Rezoning Transportation Analysis

Petition Number: 2020-120

Reviewer: Eric Lemieux, PE

Date	Description
09-11-20	First Review
10-19-20	Second Review
11-30-20	Third Review (EL)
12-28-20	Fourth Review (EL)

REZONING PLAN
RZ.01

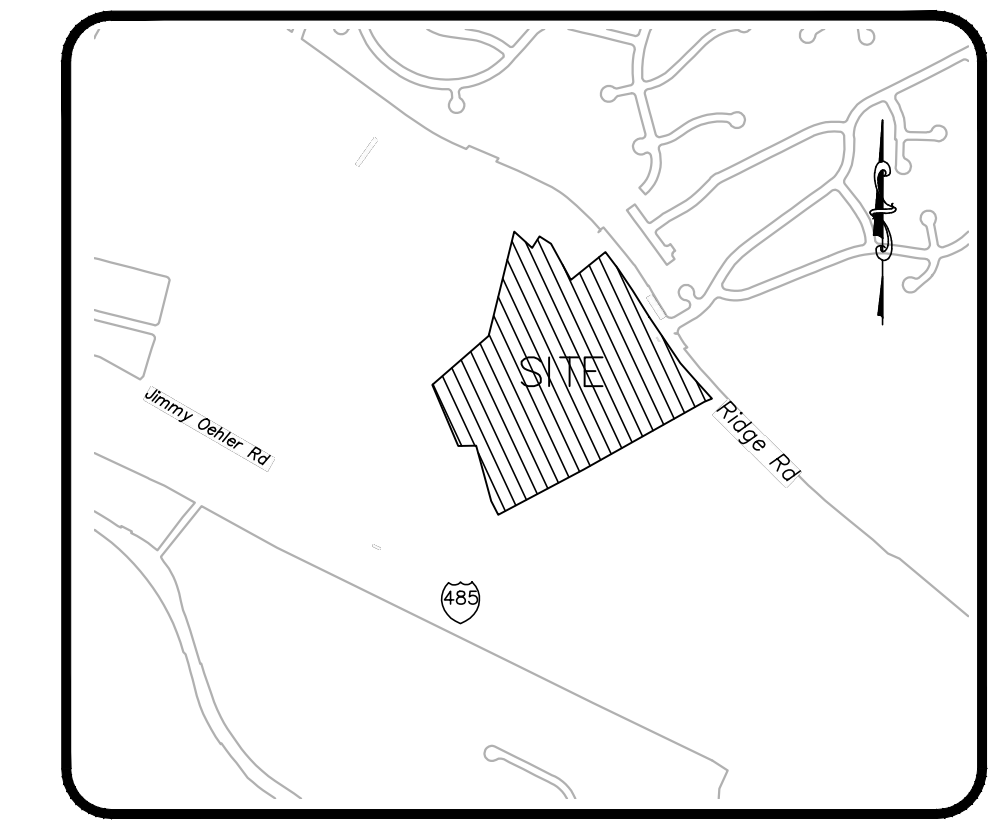
8. **Outstanding Comment (site plan dated 10.12.2020):** The petitioner should revise the site plan and conditional note(s) to update the proposed curb line, 8-ft planting strip, and 12-ft multi-use path, according to the redlines shown below. After additional review of the approved plans for **SDRMFR-2019-00041 - Redwood Ridge Road**, the development is providing an 11-ft center turn lane, as opposed to the 10-ft center turn lane that was recommended within the Prosperity Hucks Area Plan. **This three-lane section should be provided along the entire property frontage along Ridge Road.**

- a. **Technical Clarification (site plan dated 12.14.2020):** Revise the site plan and conditional note (**Section C.5**) to confirm that a three (11-foot) lane section will be constructed according to CDOT standards, along the entire property frontage of Ridge Road. The updated site plan indicates widening, but a consistent three (11-foot) lane road section needs to be provided along the entire frontage. The current site plan proposes varying lane widths. This may be reviewed in detail during permitting, and the required widening will occur asymmetrically.

REZONING PLAN
RZ.01

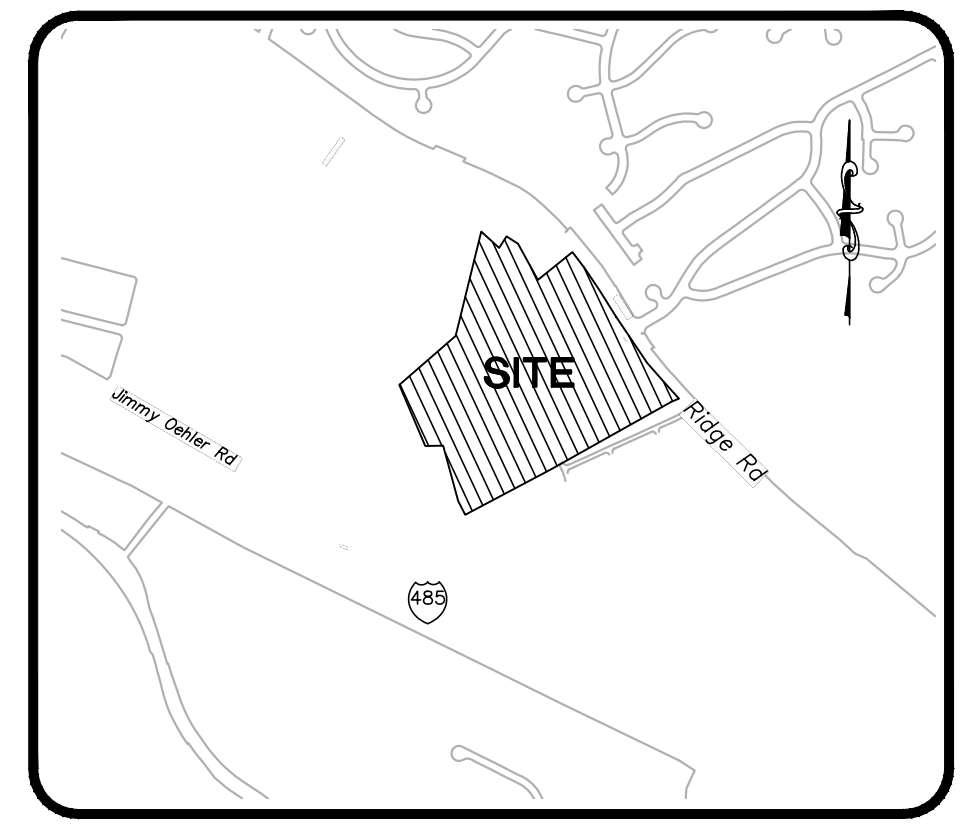
9. **Outstanding Comment (site plan dated 10.12.2020):** The petitioner should revise the site plan to accommodate a private driveway designated for the future solid waste and recycling center, that allows space for all garbage truck turning movements to occur within the private drive, without maneuvering within the public right-of-way. **Please provide site plan note stating that garbage truck turning movements will occur outside of public right-of-way.**
